**WELWYN HATFIELD BOROUGH COUNCIL
EXECUTIVE DIRECTOR - PLANNING, PUBLIC PROTECTION AND GOVERNANCE**

DELEGATED APPLICATION

Application No: 6/2019/0838/HOUSE
Location: 6 Bluebell Way Hatfield AL10 9FJ
Proposal: Erection of a bicycle shed-Retrospective
Officer: Mr A Commenville

Recommendation: Granted

Diagram 20

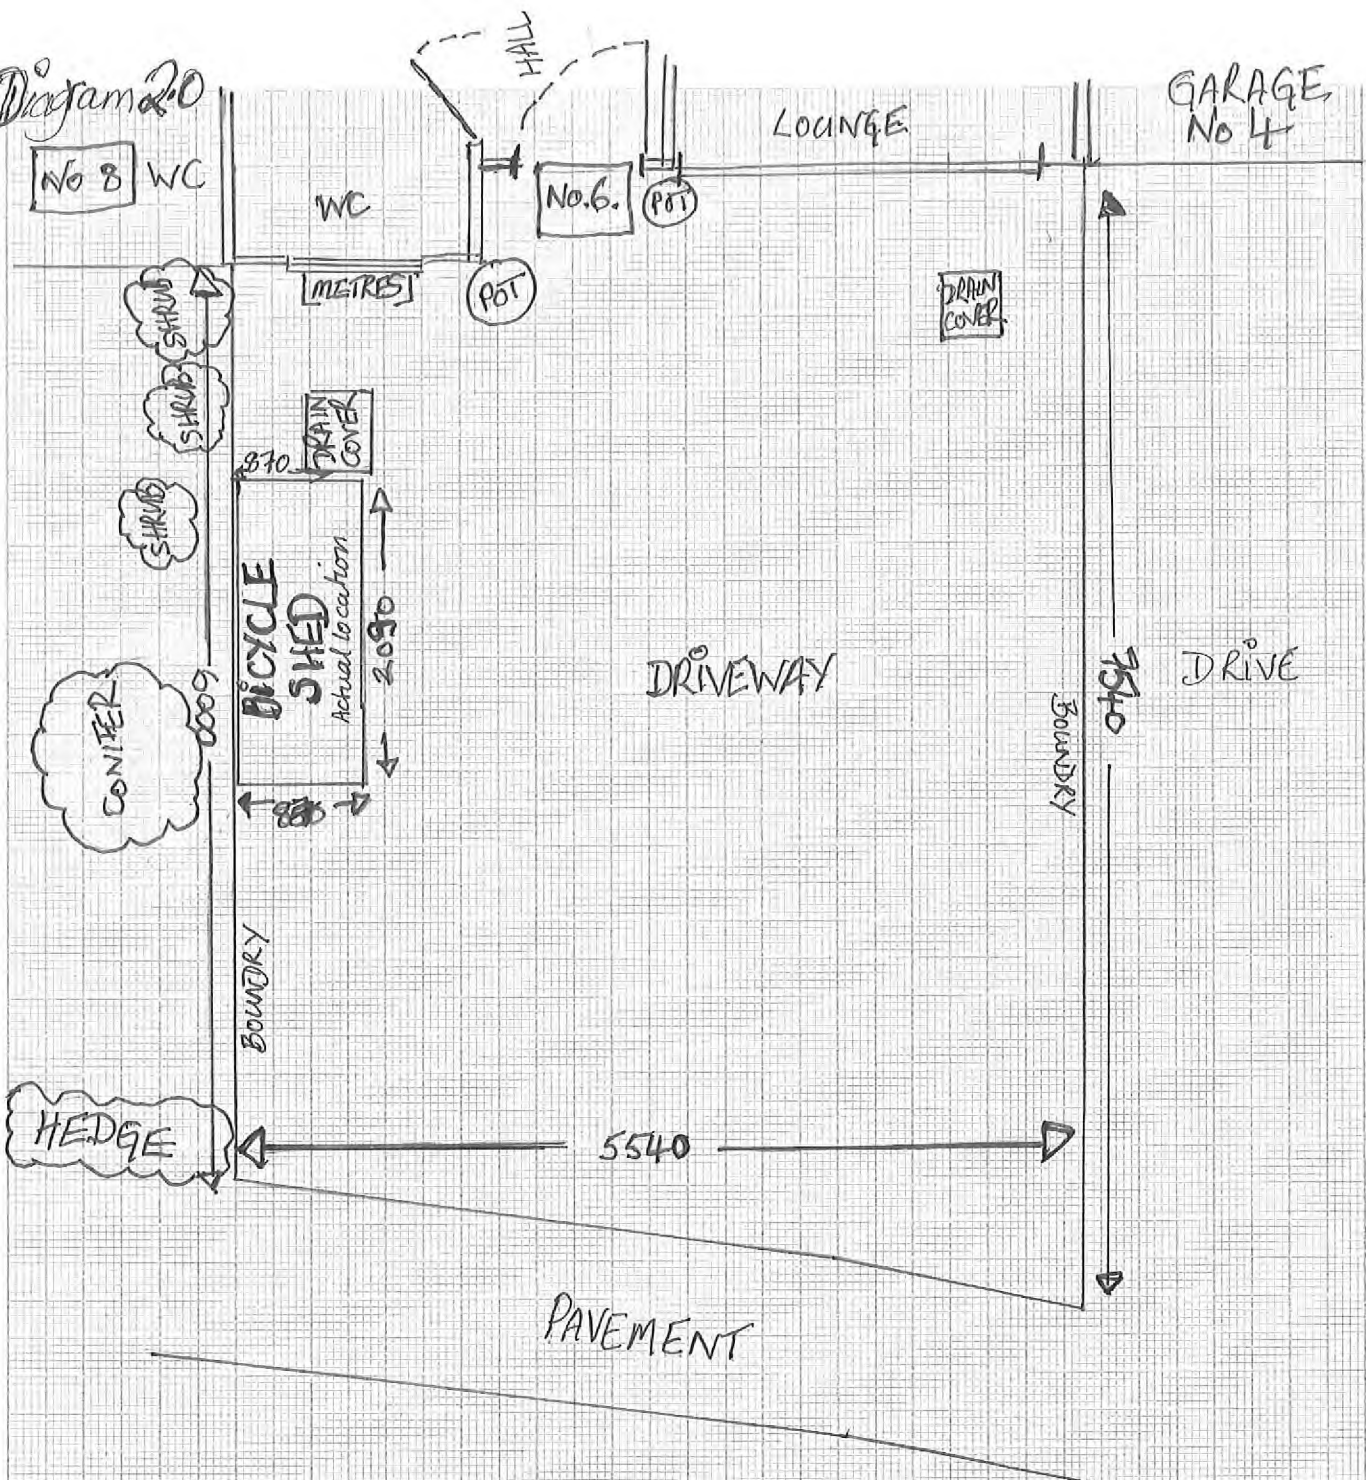
Comment (if applicable): The proposal seeks planning permission to retain a bicycle storage. The outbuilding measures approximately 2m in depth, 0.85m in width, 1.7 metres in height with a mono-pitched roof having eaves level at 1.55m. Given its limited size and siting, it is considered that the bicycle store appears subordinate in scale when compared to the host dwelling and does not result in an overly cramped form of development. The white weatherboard cladding is reflective of the white windows, front door, soffits and fascias of the host dwelling. Whilst the bicycle storage is visible within the street scene and surrounding area, its impact is limited and not detrimental to the extent that would justify refusal of planning permission.

Comment (if applicable): It is noted that the bicycle store is located 1.4 metres from a ground floor front window at No. 8 Bluebell Way. However, taking into account that this window is serving a toilet, having regard to the remaining distance to this front window and considering the limited size and height of the bike storage, it is on balance considered that the proposal does not have an unacceptable impact upon the amenities of neighbouring occupiers at No. 8 Bluebell Way in terms of daylight, privacy or overshadowing to justify the refusal of planning permission. Additionally, it is noted that no objections have been raised by neighbours, the Parish Council or relevant Councillors to this planning application.

Diagram 1.0

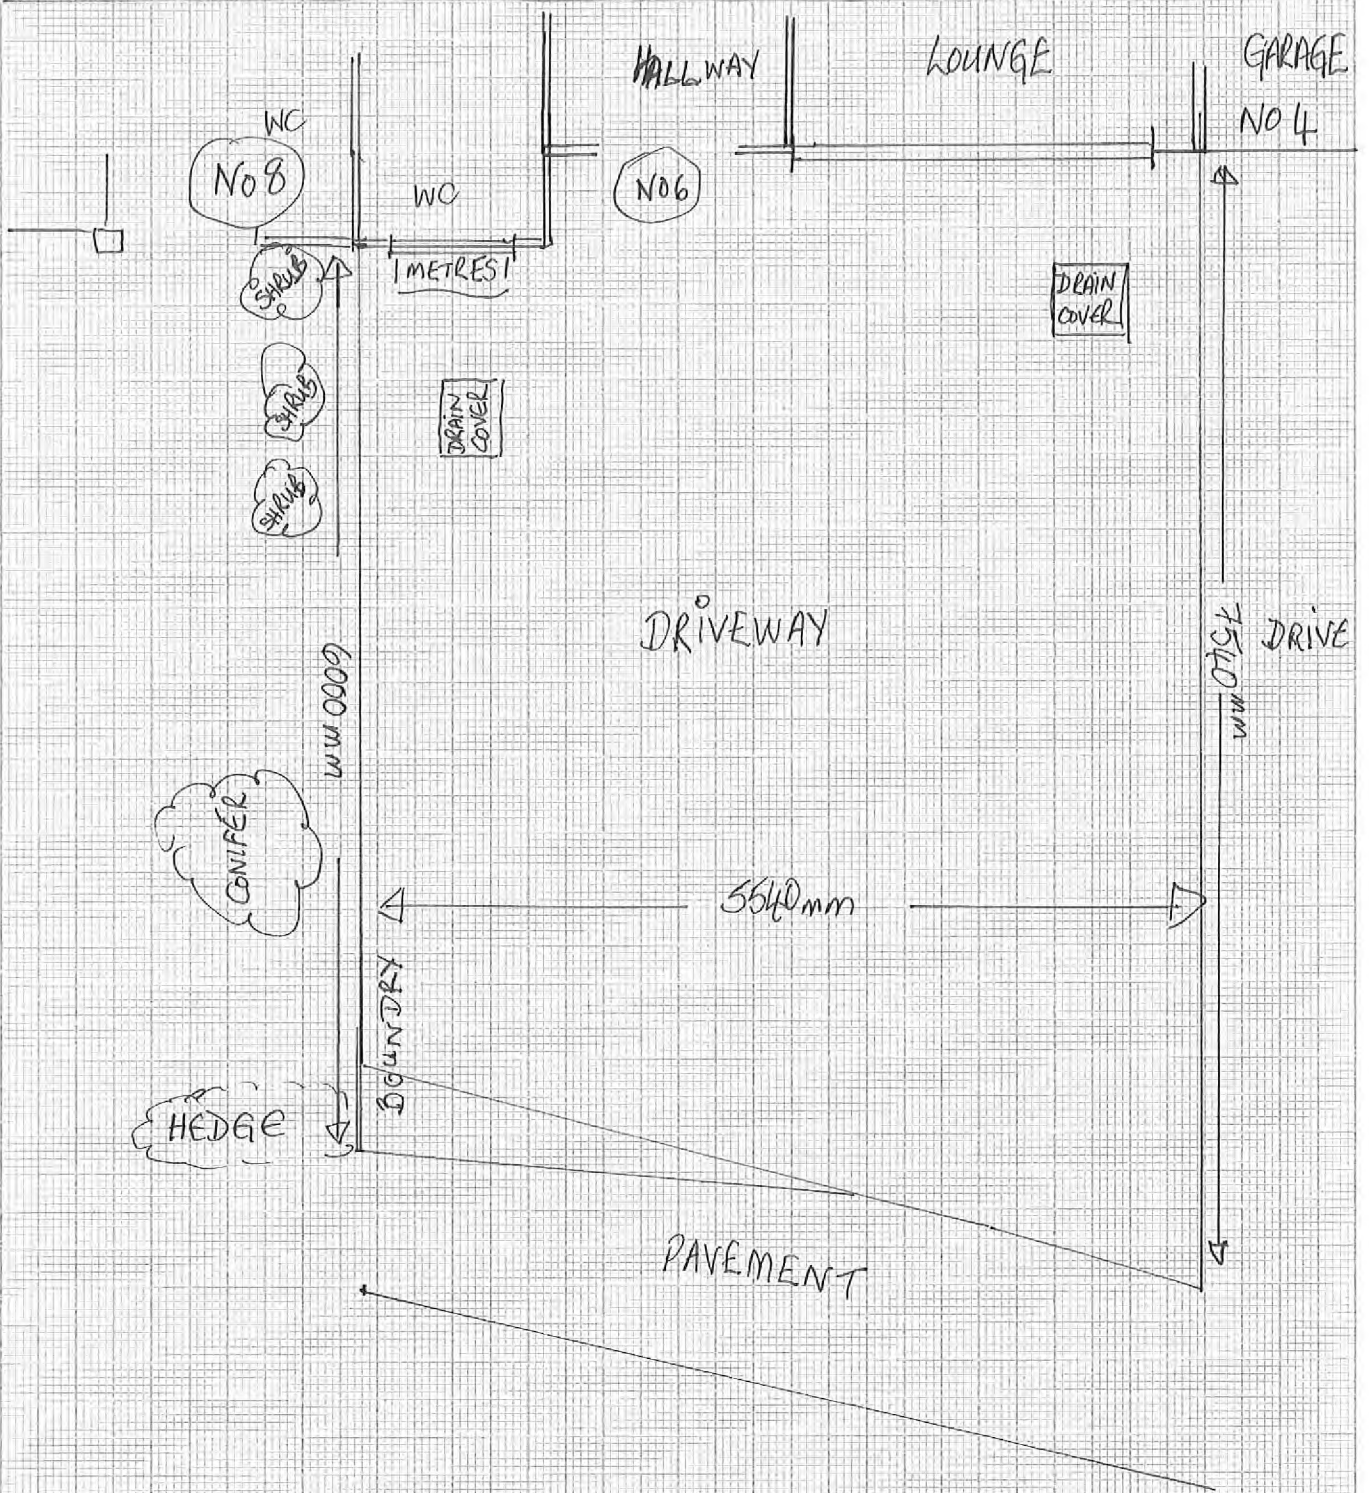
It is noted that part of the driveway is now lost through the erection of the bicycle shed. The block plan on measurement shows a retaining parking spaces for driveway of 4.7 m wide which falls short of the car parking standard dimensions for 2 no. parking spaces being 4.8 m. Given that the two parking spaces would serve a single dwelling, it would not be unreasonable for these cars to park closer together than in a public parking situation. Furthermore, it is noted that the bicycle store will increase cycling parking on site and promote alternative and more sustainable mode of transport. This is therefore on balance considered to be an improved situation between planning applications and it not considered that it would be reasonable to refuse planning permission on inadequate on-site car parking.
